Recommendation Report for Planning Permission for Works or Extension to a Dwelling

REF NO: BE/37/21/HH

LOCATION: 19 South Way
Bersted
PO21 5HB

PROPOSAL: Removal of 3 No existing lean-to structures, erection of single storey side & rear extension, loft conversion to form new 2nd floor with roof alterations to form gable end with rear dormer projection & detached outbuilding to be used as annexe to existing dwelling.

Ground floor plan
1 : 50

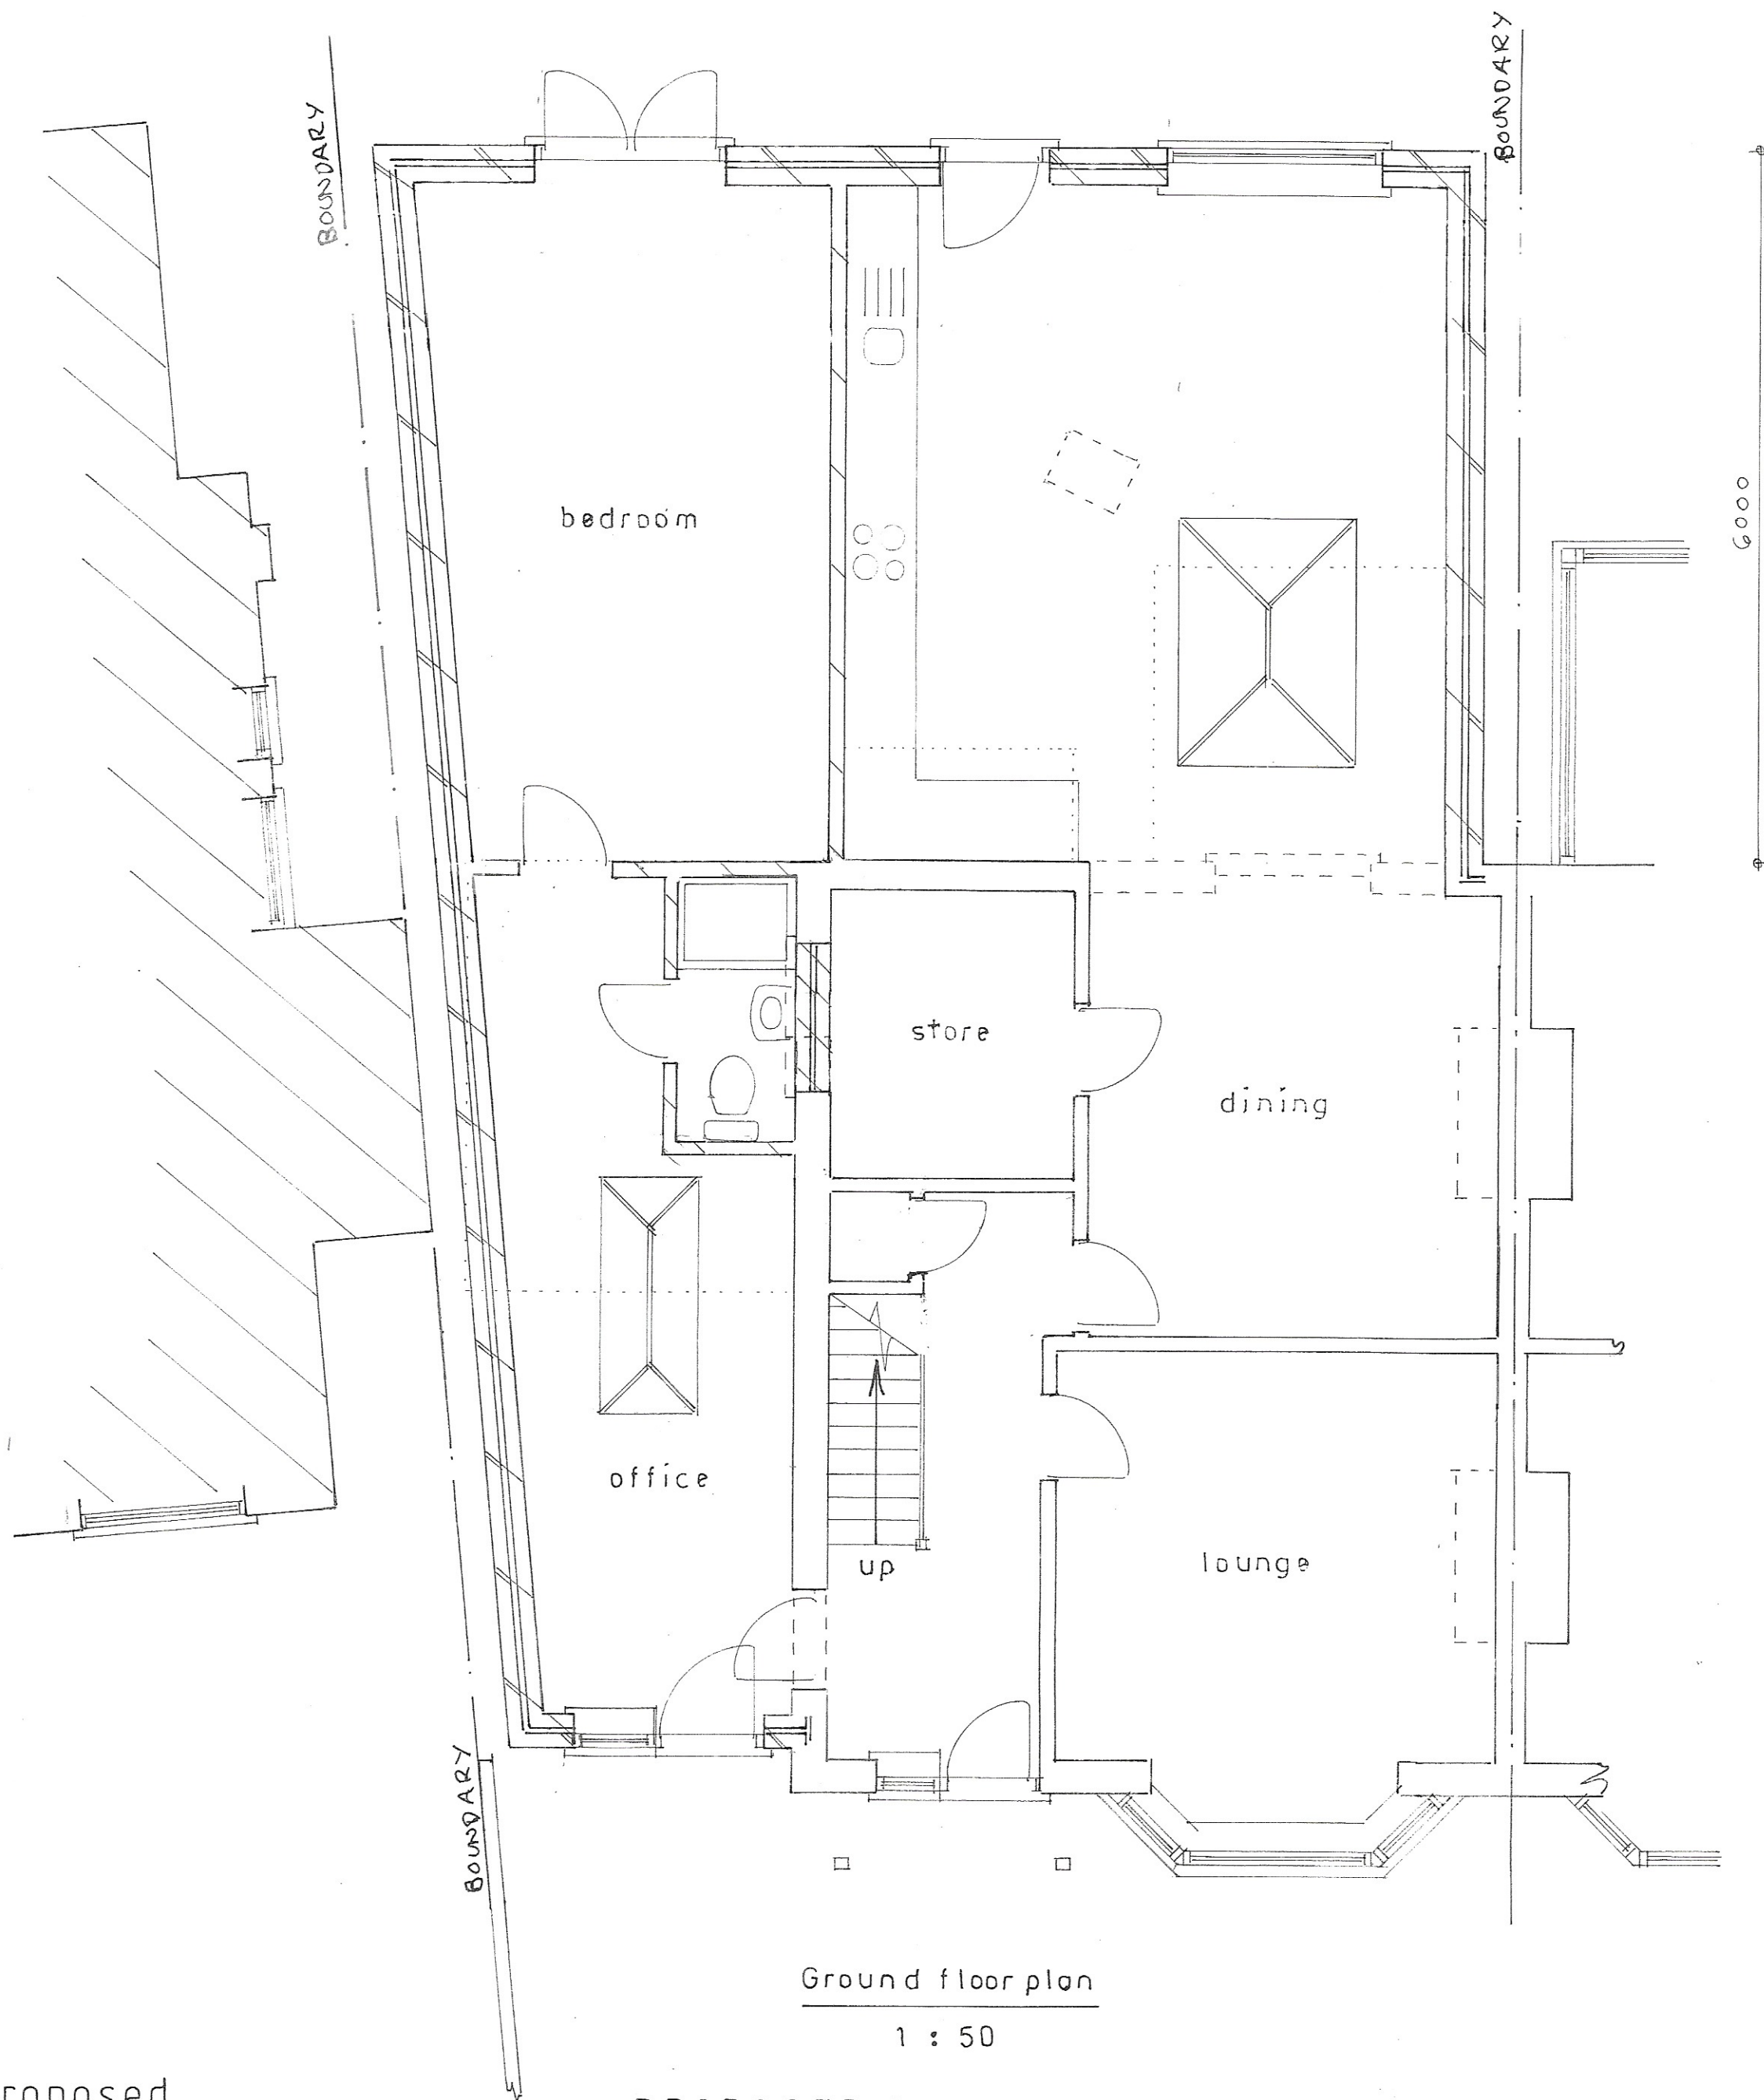
The development will have a significantly harmful impact on the residential amenities of neighbouring dwellings due to its excessive scale in such close proximity to the Southern and Northern boundaries of the site. It will have, as a result, an overbearing impact on the occupiers of the property directly to the North, #17 South Way a single storey bungalow.

The extension is at a flat roof height of 2.95m, which is approximately 0.95m above the height of the boundary treatment fencing between the site and 17 South Way at a distance of approximately 0.3m from the boundary line. At a length of 13.5m, this is considered to result in a significantly harmful overbearing impact upon the occupiers of 17 South Way as the roof will have a significant visual bulk when within 2m of the boundary. It is also considered that the extension will have an adverse impact on 21 South Way with 6m at 2.95m on that boundary.

- 1 The rear extension and annexe due to the height, length and siting and size are overdevelopment resulting in an unneighbourly and unacceptable overbearing effect on the occupiers of 17 and 21 South Way contrary to policies D DM1 and D DM4 of the Arun Local Plan.
